# KITTITAS COUNTY

## DEPARTMENT OF PUBLIC WORKS

TO: Mackenzie Moynihan, Community Development Services  
FROM: Christina Wollman, Planner II *aw*  
DATE: June 12, 2008  
SUBJECT: Gerard Plat LP-08-12

GERARD PLAT
 PART OF SECTION 14, T. 18 N., R. 18 E., W.M.
 KITITAS COUNTY, WASHINGTON
 -- PRELIMINARY PLAT --

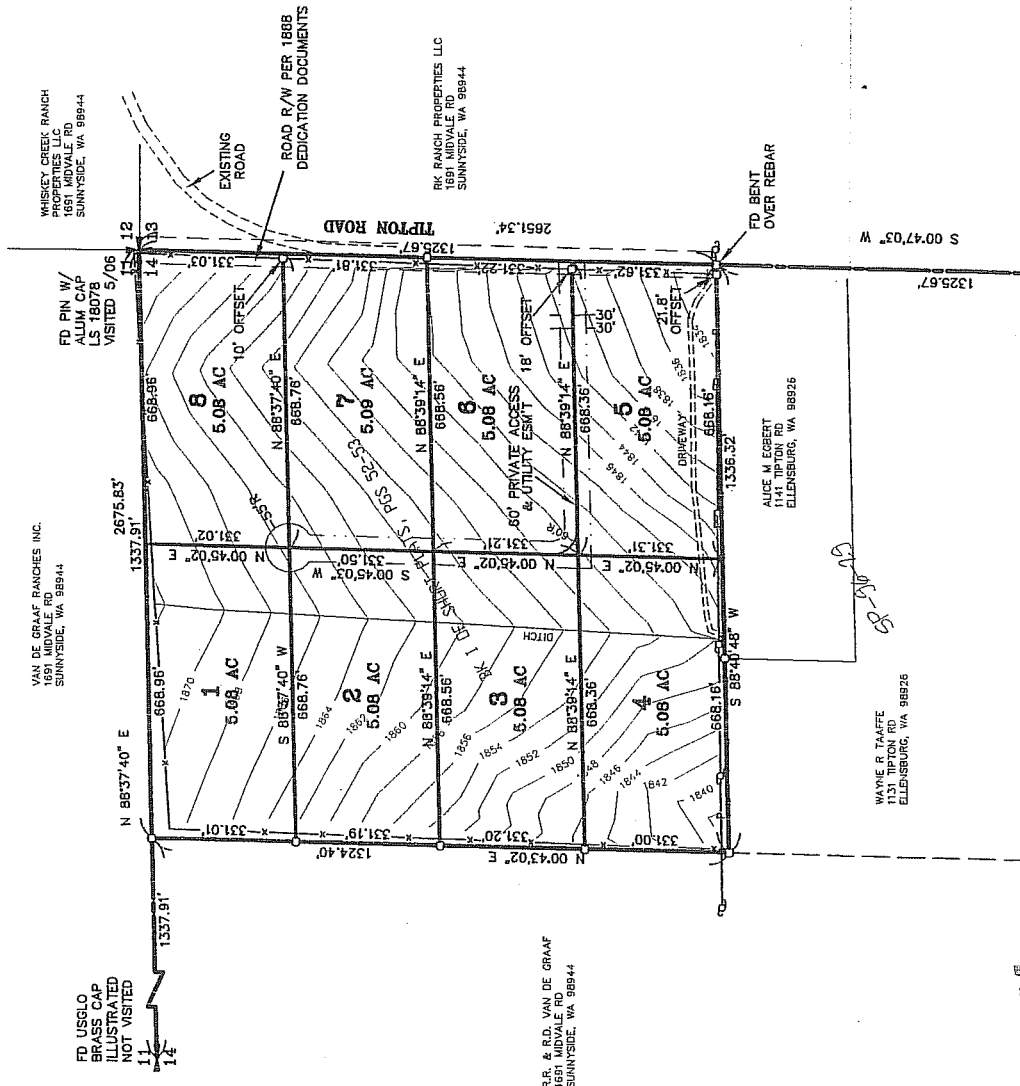
1. Right of Way Dedication: The applicant shall dedicate 30' of right of way for Tipton Road to Kittitas County. The right of way shall be 30' west of the section line for the extent of Tipton Road.

2. Access: All access shall be from the private road. No direct access to Tipton Road shall be allowed.
3. Private Road Certification: Private roads serving any of the lots within this development shall be inspected and certified by a licensed professional engineer for conformance with current Kittitas County Road Standards, 9/6/05 edition. Kittitas County Public Works shall require this road certification to be completed prior to the issuance of a building permit for any of the structures within the proposed plat.

4. Private Road Improvements: Access from Tipton Road to the cul-de-sac shall be constructed as a Low-Density Private Road. See Kittitas County Road Standards, 9/6/05 edition.

- a. Access easements shall be a minimum of 60' wide. The roadway shall have a minimum width of 20', with 1' shoulders, for a total width of 22'.
  - b. Minimum centerline radius will be 60'.

- c. The surface requirement is for a minimum gravel surface depth of 6".

- d. Maximum grade is 12%.
  - e. Stopping site distance, reference AASHTO.
  - f. Entering site distance, reference AASHTO.
  - g. Maintenance of driveway approaches shall be the responsibility of the owner whose property they serve. The County will not maintain accesses.

- j. All easements shall provide for AASHTO radius at the intersection of county road.
  - k. A paved apron shall be constructed at the intersection of the proposed private intersection and the county road right of way.

5. Cul-de-Sac: A cul-de-sac turn-around having an outside right-of-way easement diameter of at least 110 feet shall be constructed at the closed end of all dead-end roads serving 3 or more lots. The driving surface shall be at least 96 feet in diameter. Cul-de-sacs must also conform to the requirements specified by the 2006 International Fire Code. Contact the Fire Marshal regarding any additional cul-de-sac requirements.
